Consultee Comments for Planning Application 24/00559/FU

Application Number: 24/00559/FU

Address: 2 Millbeck Green Collingham Wetherby LS22 5AF

Proposal: Erection of Outbuilding to rear

Proposed Fencing

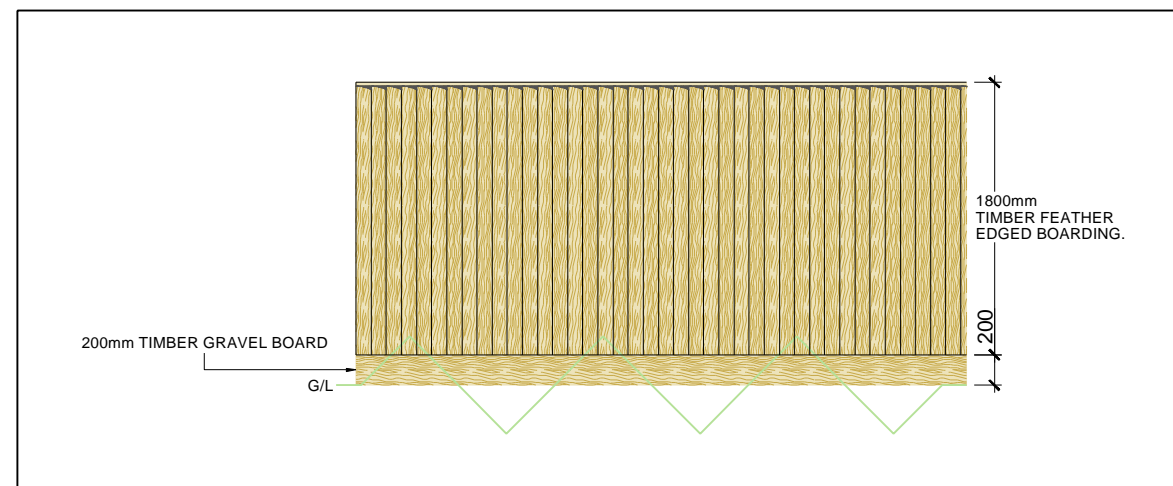
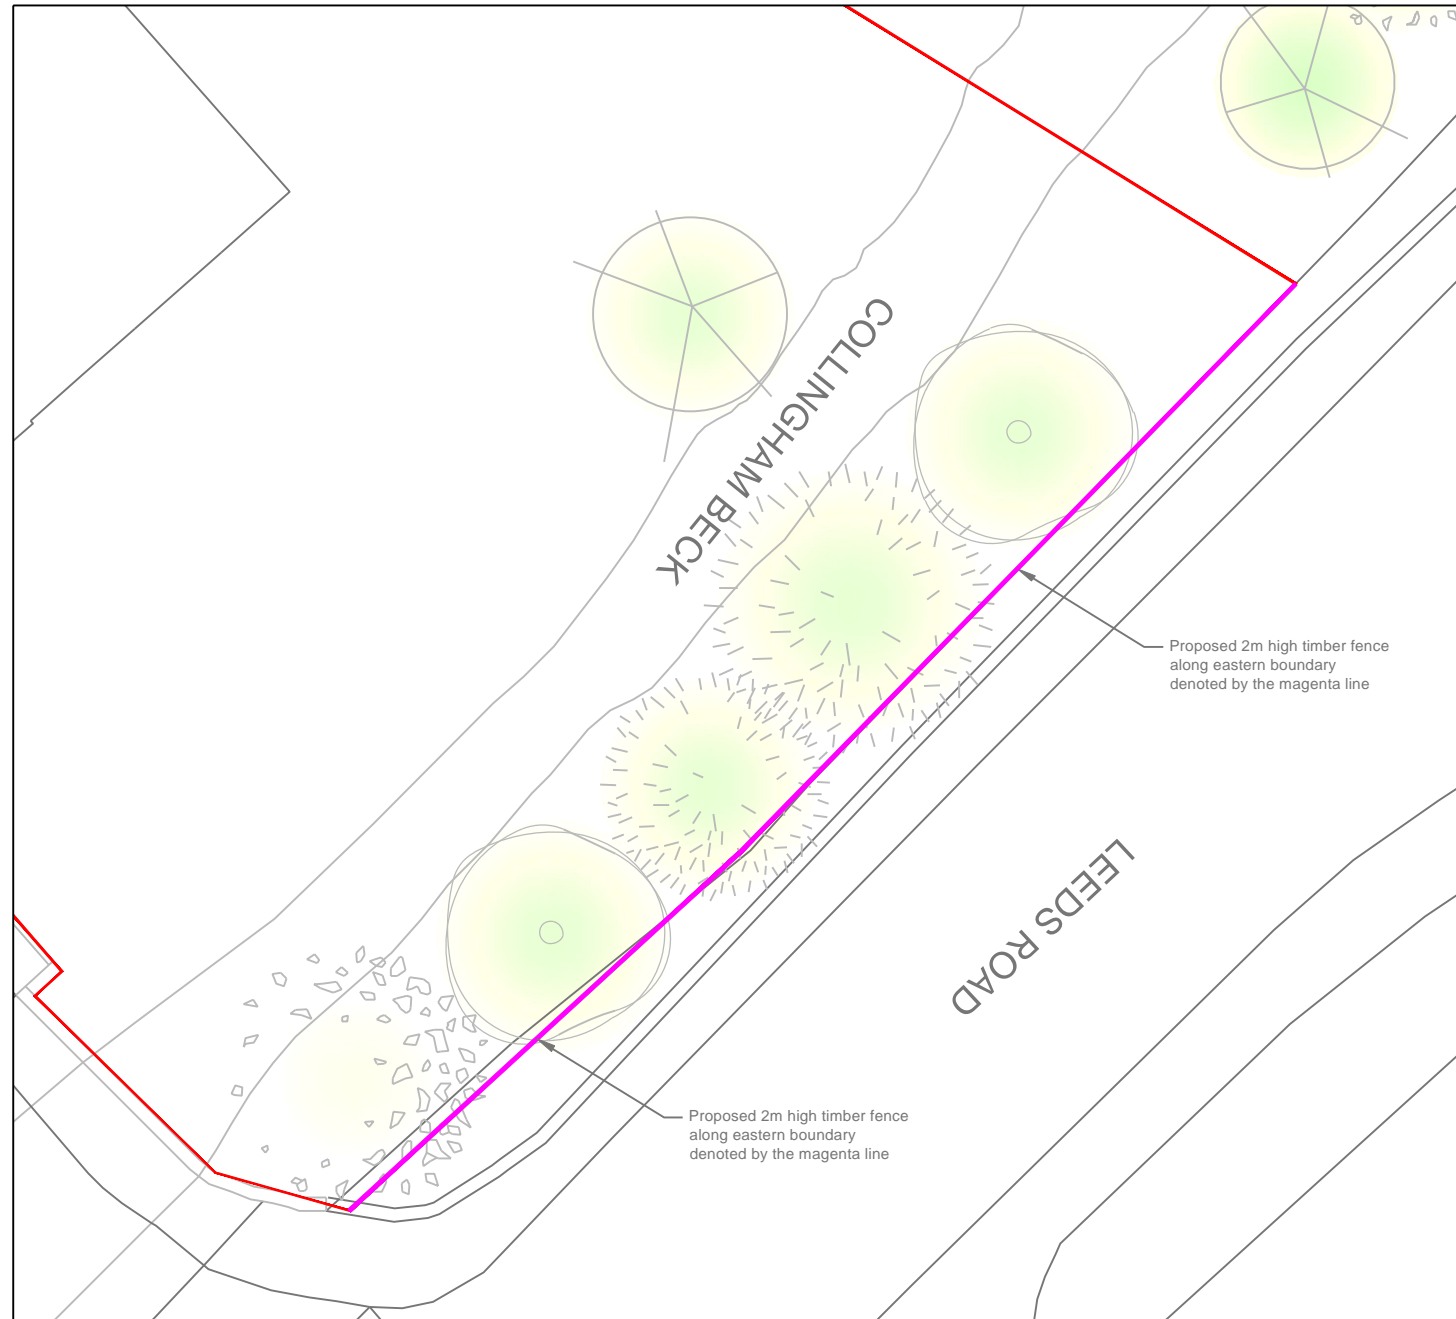
Collingham with Linton Parish Council wishes to object to the proposed fence adjacent to the A58.

The boundary of the Conservation Area runs along the beck and the line of the proposed fence is therefore within the Conservation Area. A less visible fence may be more appropriate, together with additional infill planting. We note the applicant has planted some laurel. The Parish Council received a complaint about this planting from a resident who suggested more native species would be more appropriate. A reduced height fence set behind the vegetation may be more appropriate, and possibly this could be painted green.

In summary, the Parish Council objects to the proposed fence on the grounds of unacceptable visual impact within the Conservation Area. The outbuilding however is considered acceptable (outside the Conservation Area, probably is permitted development anyway).
